From: Laura Gibbons <Laura.Gibbons@arun.gov.uk>
Sent: 08 June 2021 16:29
To: Planning.Responses <Planning.Responses@arun.gov.uk>
Cc: Simon Davis <Simon.Davis@arun.gov.uk>
Subject: RE: Planning Consultation on: Y/49/21/RES

We are unable to provide support to the reserved matters application at this time. The outline decision notice requires surface water drainage to be agreed at or before reserved matters. **We therefore raise a holding objection at this time.**

Application No: Y/49/21/RES
Registered: 19th April 2021
Site Address: Land East of Drove Lane Yapton BN18 0EB
Grid Reference: 497380 103194
Description of Works: Approval of reserved matters following Y/92/17/OUT for 300 No. dwellings covering landscape, layout, scale & external appearance (resubmission following Y/78/20/RES). This application affects the setting of listed buildings, affects the character & appearance of the Main Road/Church Road, Yapton Conservation Area & affects a Right of Way. This site falls within Strategic Site SD7 (Zero Rated).

Granular Blanket Below Detention Basin
Pond 2

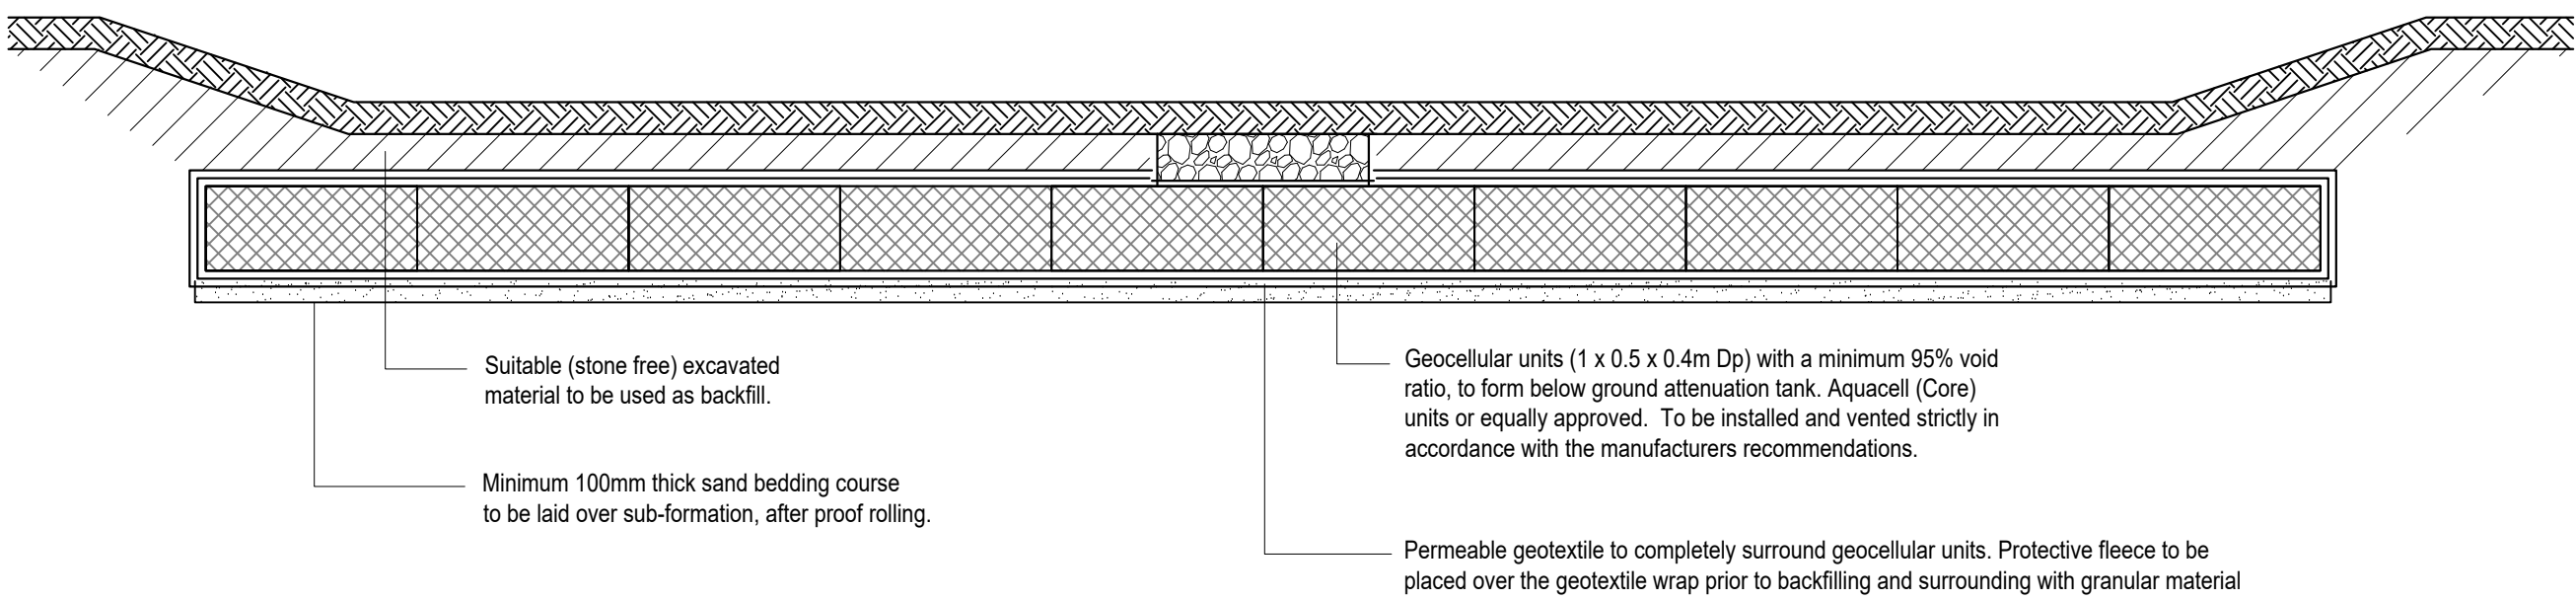
14. Please clearly show permeable geotextile around the granular sub-base to pond 2. Permeable geotextile added to detail around the gravel blanket as requested in this comment. *This needs to show the wrap around the top of the granular sub-base too.*

15. The layout states that the gravel will have an impermeable geotextile below it. Please include this on the construction detail drawing. Refer comment 14 above. Permeable geotextile has been detailed and reference to an impermeable geotextile has been removed. *Groundwater monitoring will be reviewed once supplied to AOD, and acceptability of permeable liners commented on.*

Geocellular Storage Below Detention Basin Pond 7 / SA25, Pond 8 / SA15, Pond 9 / SA23

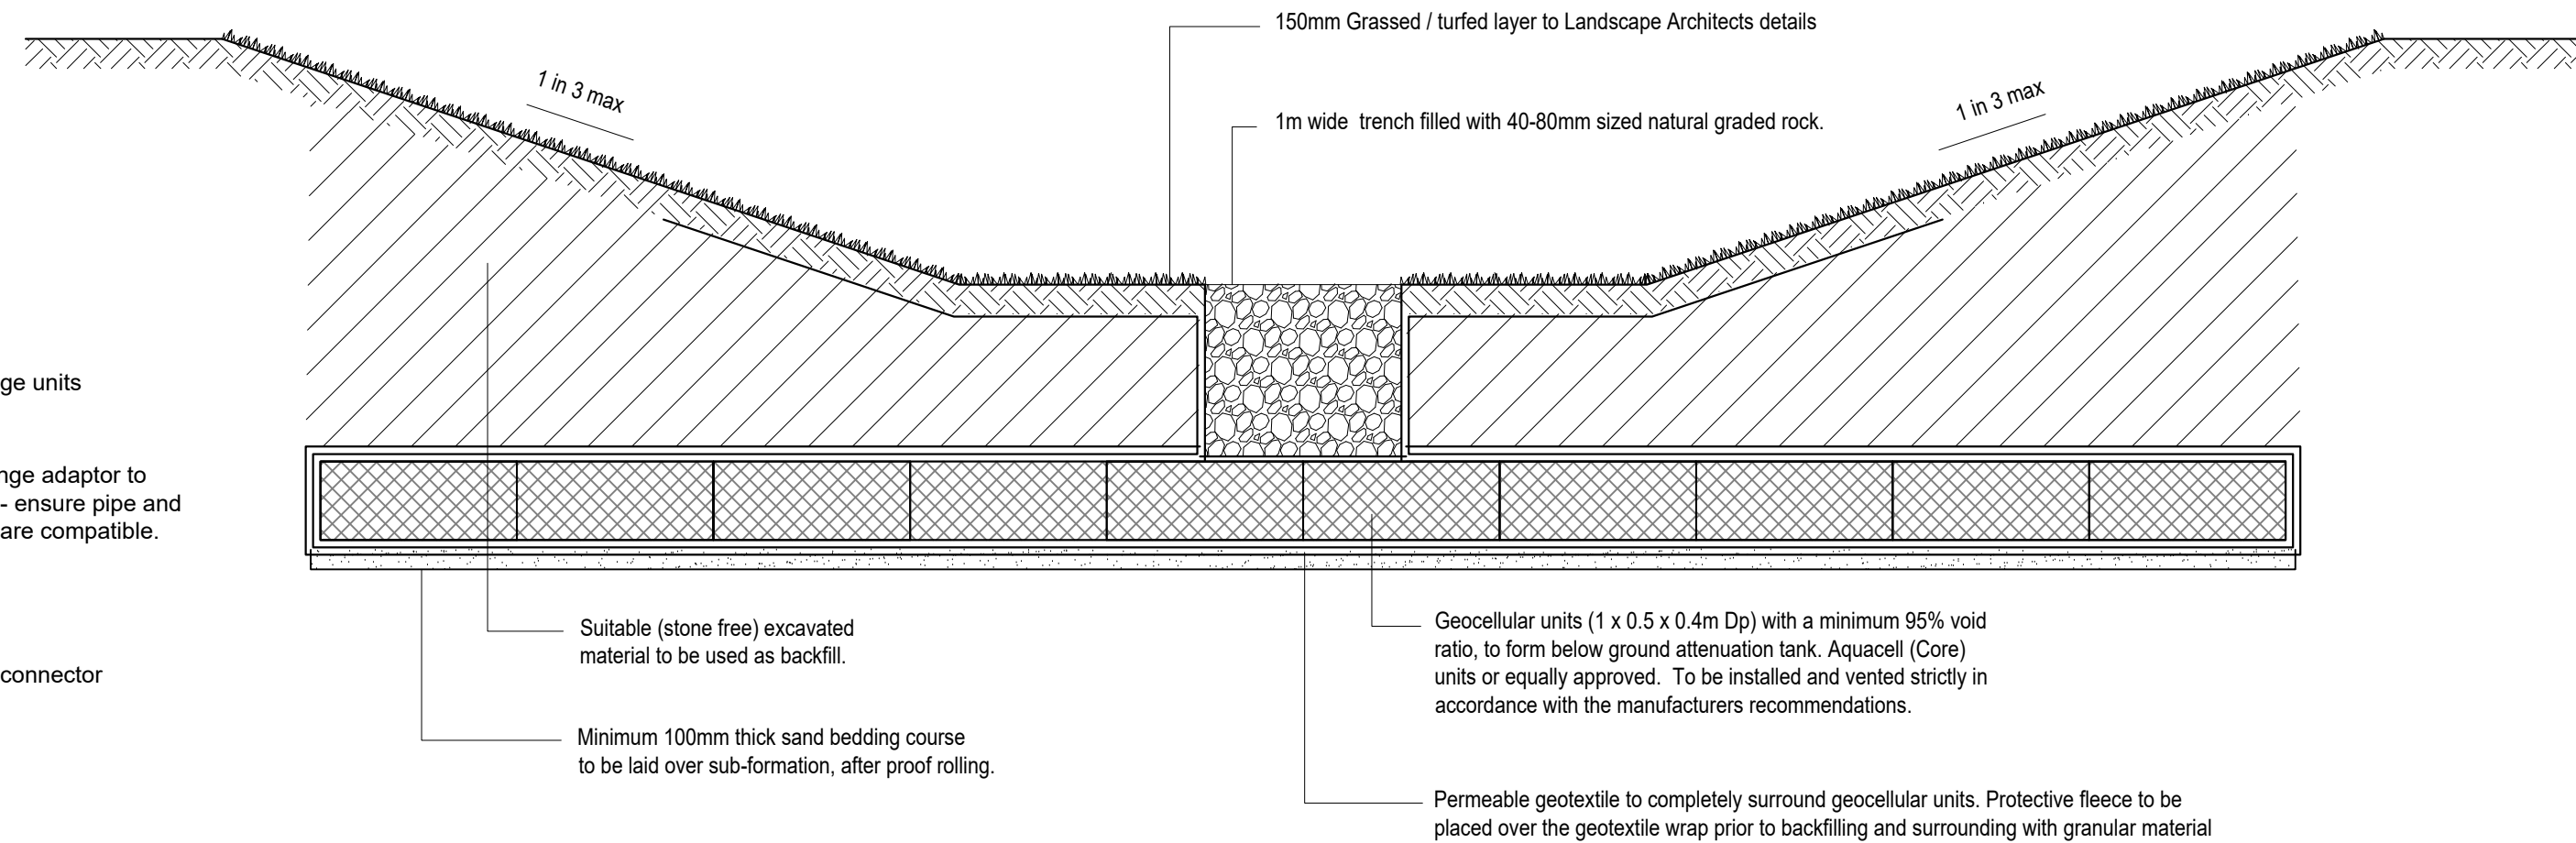
13. The geocellular storage below pond standard detail- please include a geotextile surround around more of the trench which links the pond and crates. The depth of sacrificial stone which will need frequent replacement due to sedimentation should be reduced. E.g. just 200-300mm of stone on

top of 700mm geotextile surrounded trench. – Permeable geotextile added to detail as requested. Okay, point closed.

Trench Soakaway detail (SA1)

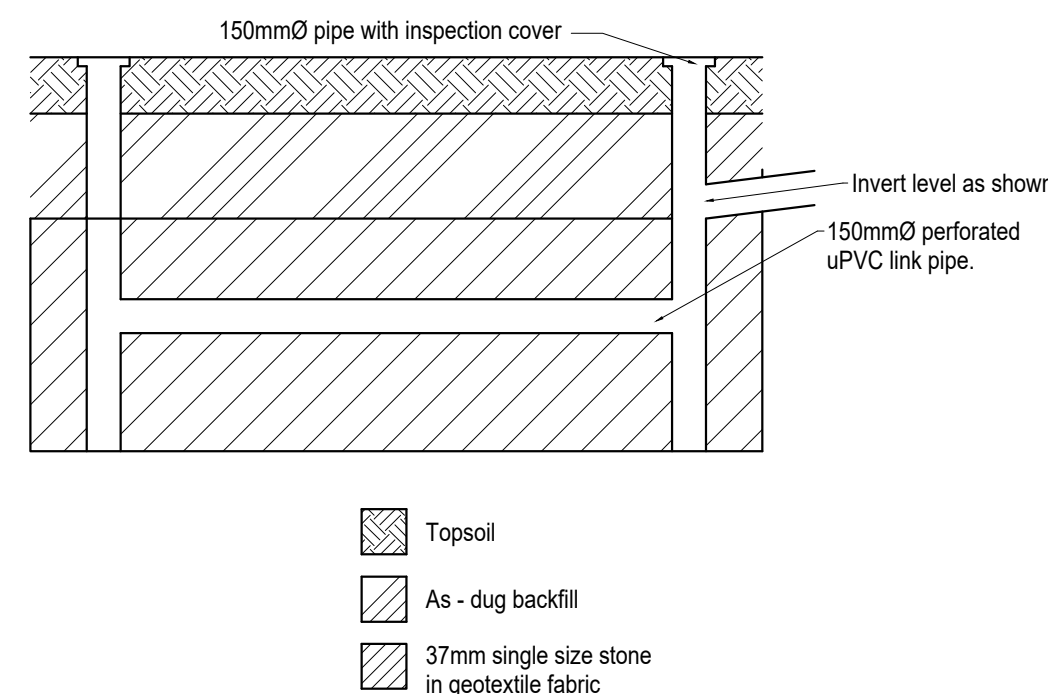
3. All incoming connections to soakaways, etc. require catchpits. Please add clarity to the layout plans. — Catchpits are indicated for all manholes before incoming connections to soakaways and ponds. Text is shown next to manhole information. *Catchpits do not appear to be identified on numerous connections into SA1, please review.*

8. Soakaway 1 has an outlet much higher than the base, this should be accounted for in design calculations, i.e. storage should only be counted above the outgoing outlet level. — Calculations have been updated to suit this.

2. There is no cover depth above SA1, the base of the trench is located 1m below cover level, and the storage is 1m depth (both on calculations and plans). — Base of SA1 is 5.60, cover level is 6.60, proposed ground level is on average 6.75/6.8 giving 150mm cover minimum. Calculations will change as per comment 8 above. *okay, point closed.*

Infiltration enhanced swale with 225mmØ 360° perforated pipe SW1, SW3, SW4, SW5, SA5, All Roadside enhanced swales

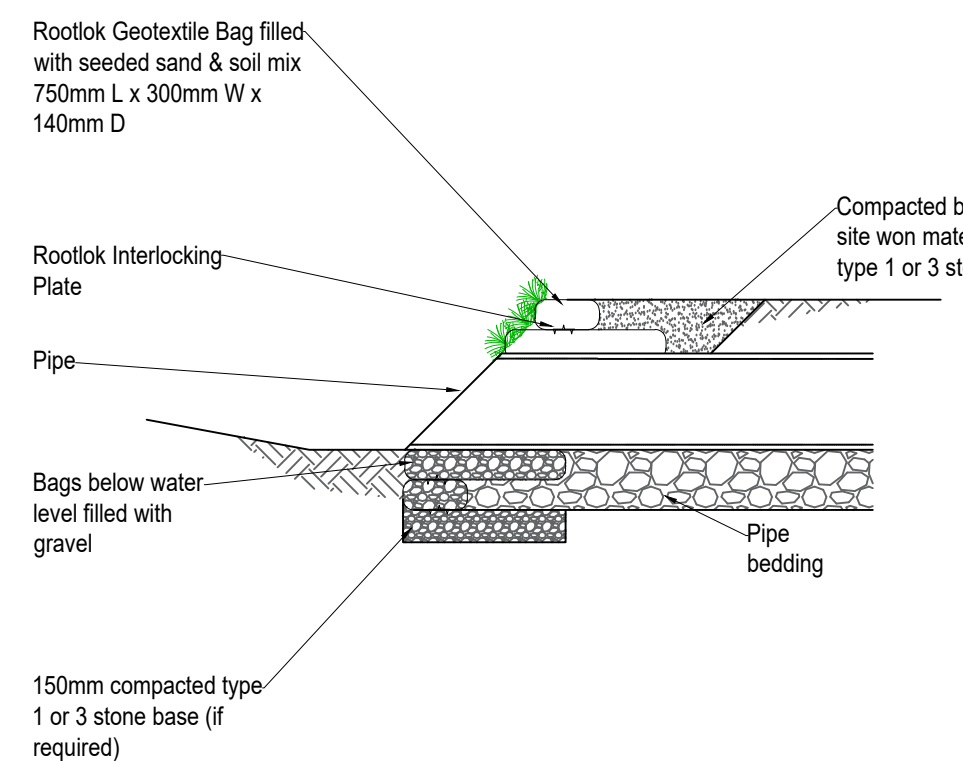
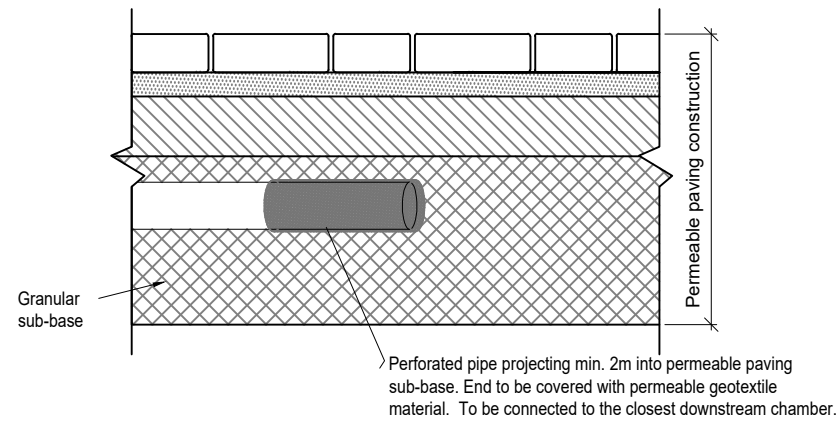
10. On construction details of enhanced swales please detail base width and side slopes. – The base width varies as noted on the detail, refer to the plan for base width of the different enhanced swales. Widths of side slopes also vary and are set at 1:3. *We would prefer to see a table on the construction details stating these dims for each swale.*

11. The construction detail of the enhanced swales should be updated to show the permeable geotextile fully wrapping around the sub-base. There shouldn't be a gap in the middle where the swale stone connects the two features, this stone should lay on top of the fully wrapped sub-base. Ingress of fines into the sub-base will occur otherwise. – Detail updated to indicate sub-base is fully wrapped in the permeable geotextile as requested. *One enhanced swale on sheet 2 of the details is still showing a gap in the middle.*

Headwall Typical detail

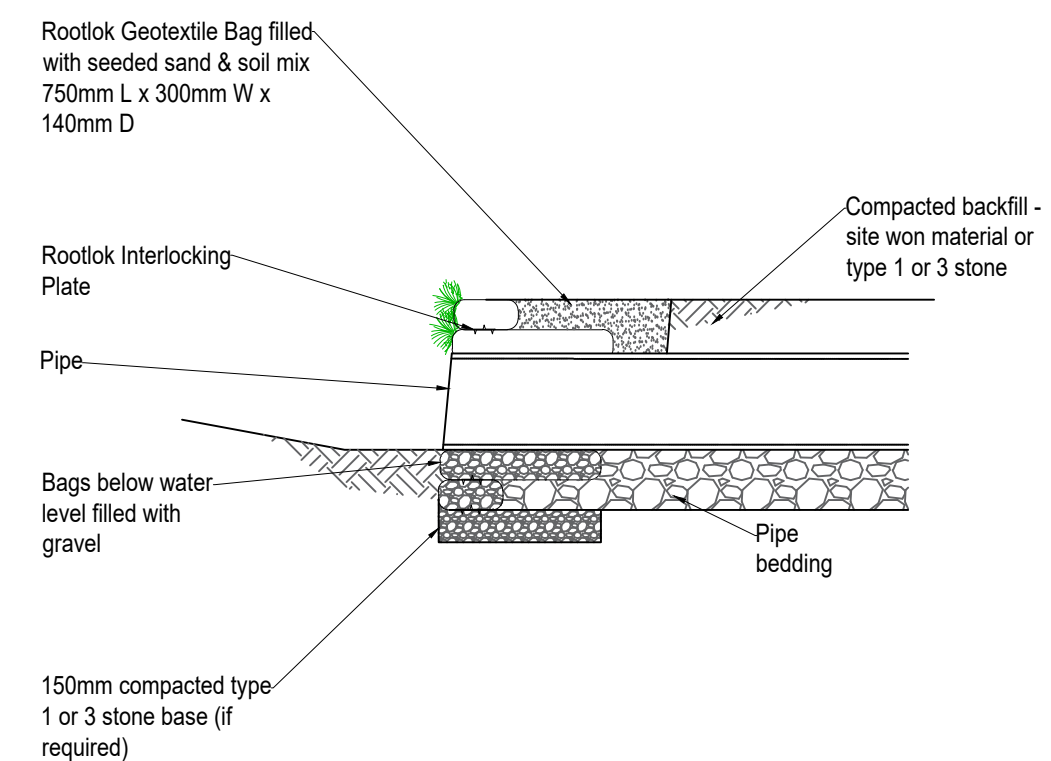
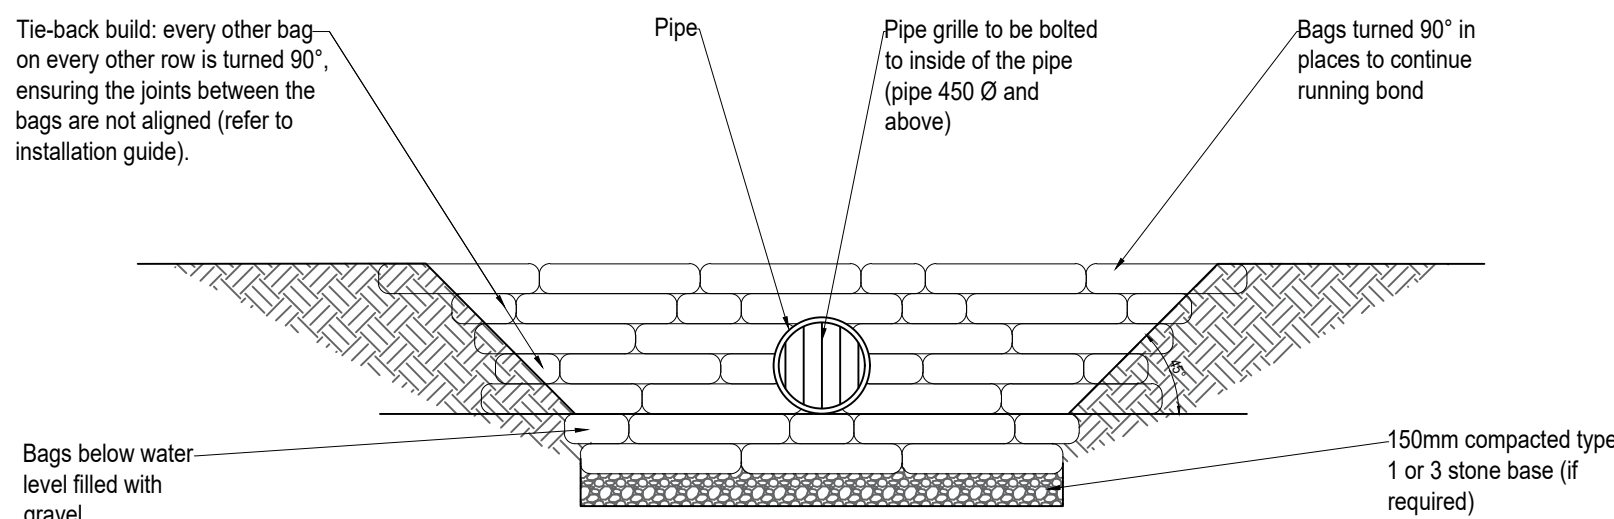
12. Please review and provide further detail on the headwall drawing. I.e. bag material, fill, packing, requirements for stakes. Bagwork headwalls should be two bags deep and in accordance with the attached standard detail. We have specified a slightly different product that has a more aesthetically pleasing green finish. We trust this is acceptable. *The details are not acceptable. We are fine to have a facing bag as you have specified, however there needs to be a solid structure behind this. We would recommend that construction details are in accordance with district and county standards with additional facing bags.*

POND 5

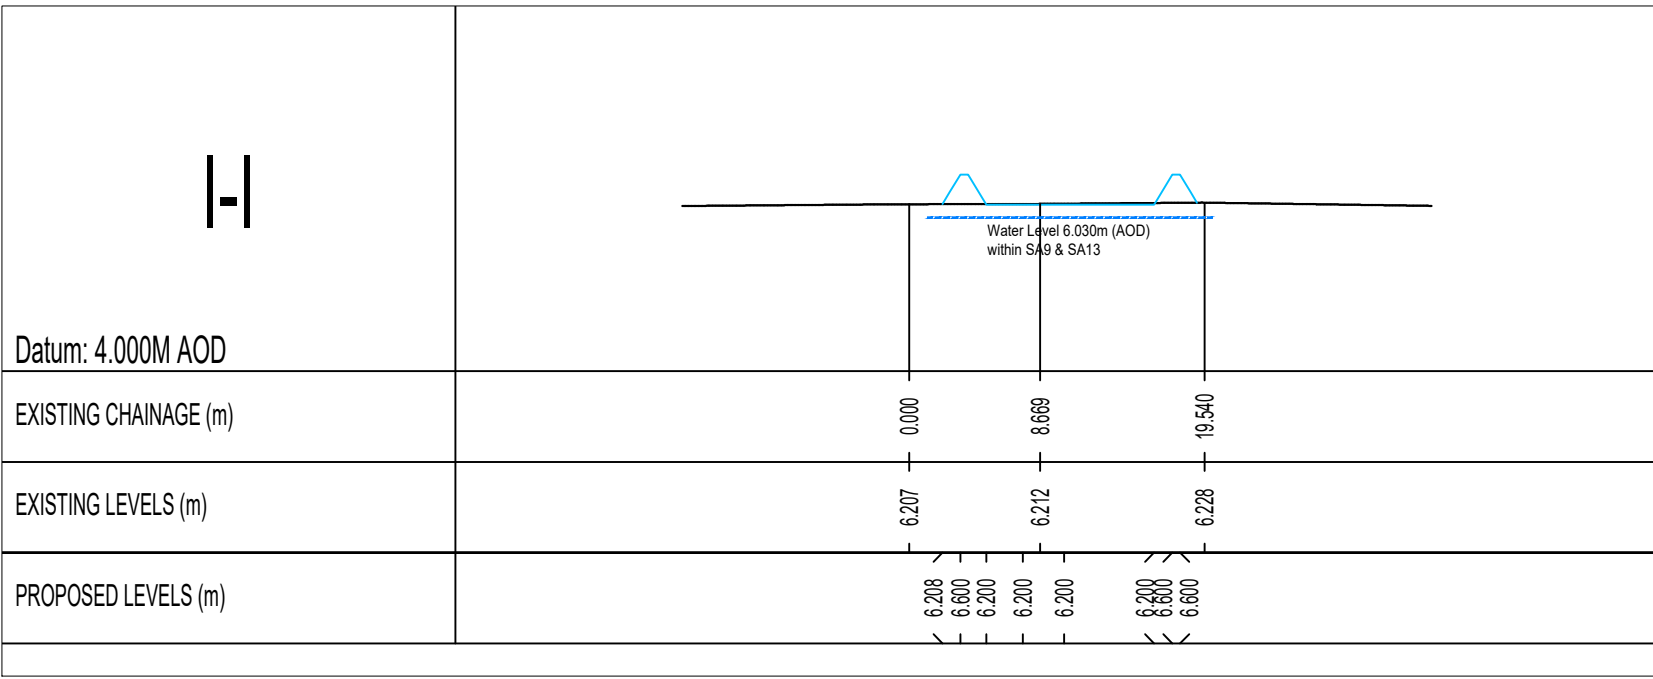
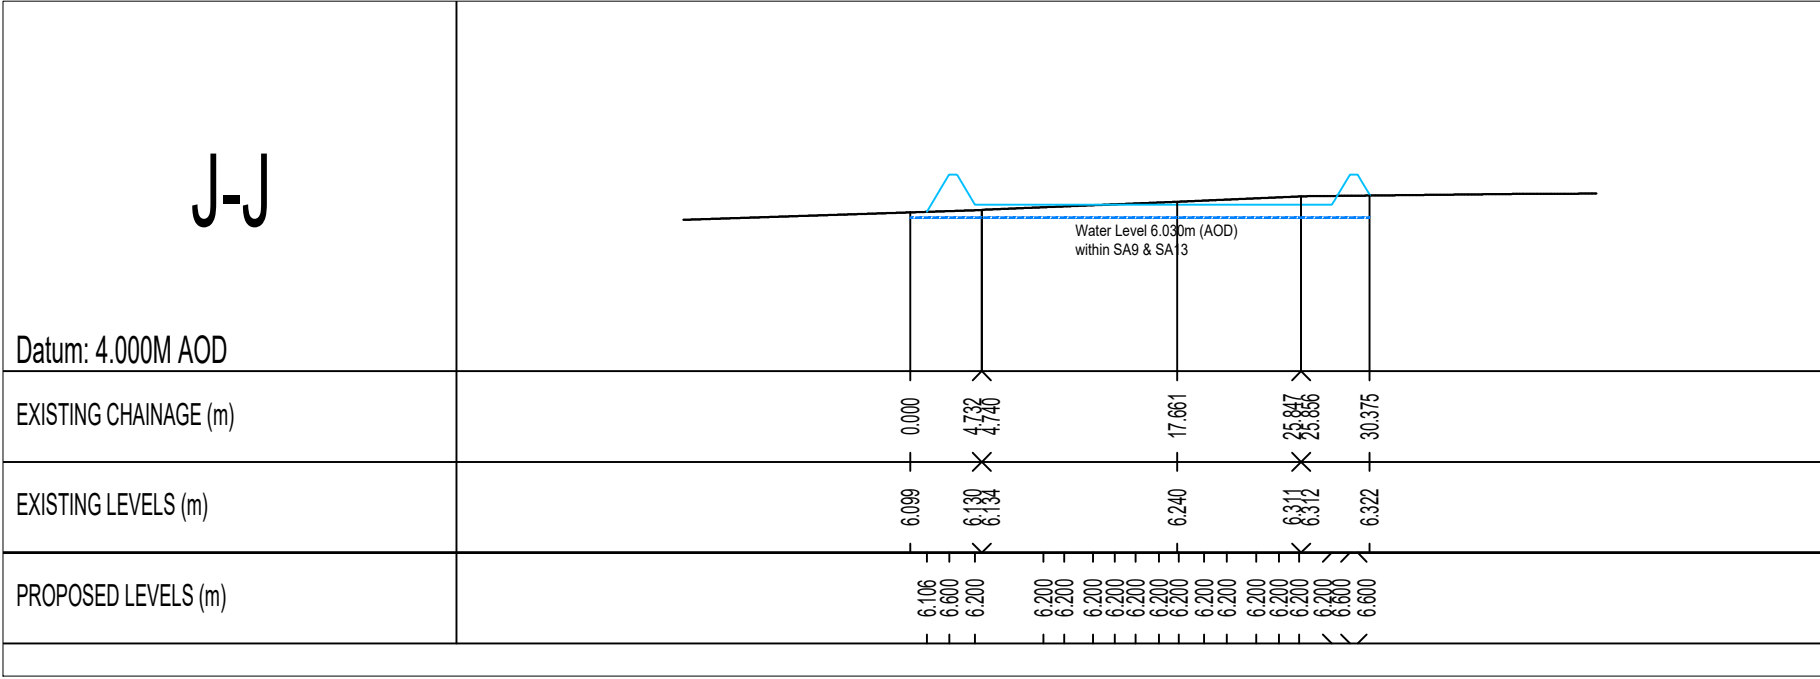
6. I note pond 5 is significantly bunded, water levels do not get into the pond, even in the most extreme event. Is there potential to provide crates, and overlying stone, with a locally raised area here to provide the required cover, instead of a pond? If not, please provide further details of the proposed bund. Pond 5 does not have bunding and ties into the proposed levels at top of bank. The bunding was indicated as the section tied back into the existing levels and not the proposed. It is 0.4m deep and is a conveyance feature. *Okay, ground raising proposals will need to be discussed with the planning officer.*
